Date: 10/31/2023

Re: **Window Header Issue**
Location: Lot 44 Honeycutt Hills (Angier, NC)
JDS Project No.: RDU2310464
Date of Inspection: 10/31/2023

SHEET No. A.II

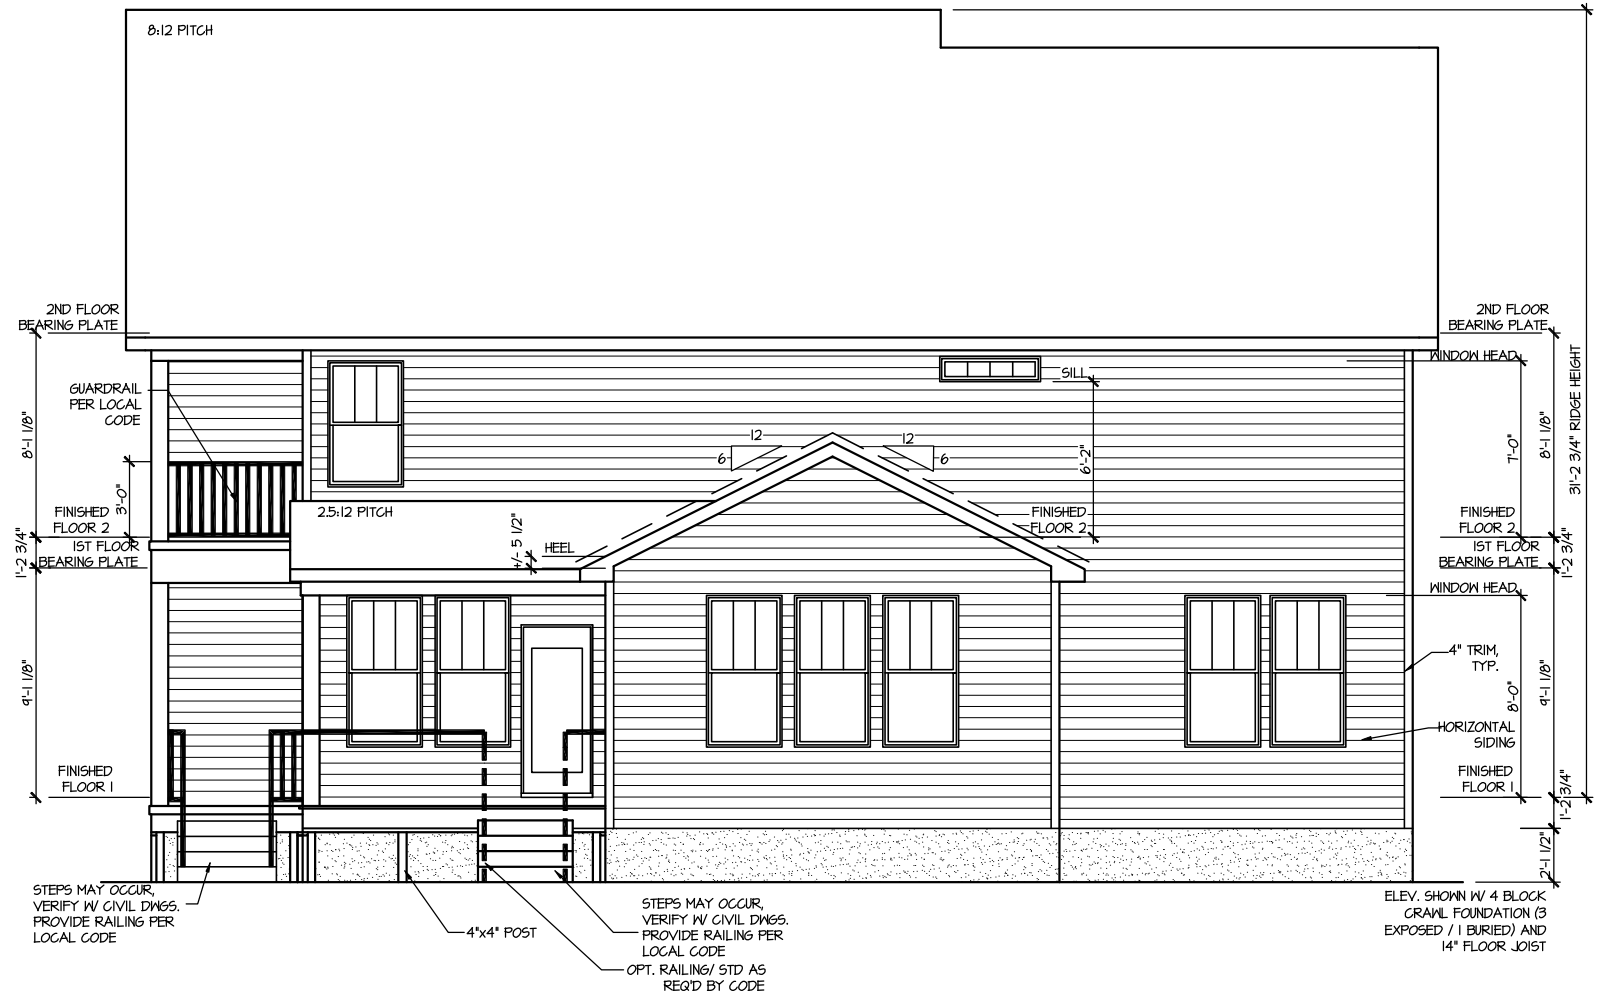
- Installed the window headers above the family room, breakfast room, and the loft with (1) jack stud and (1) king instead of installing with (1) jack stud and (2) king studs per the building plans.

Based on our on-site evaluation and review, Install (1) Simpson CS16 strap on the jack studs between the windows at all locations. The straps shall extend from the top plate across the header and extend 12" onto the jack stud below, install the strap per the manufacturer's installation instructions.
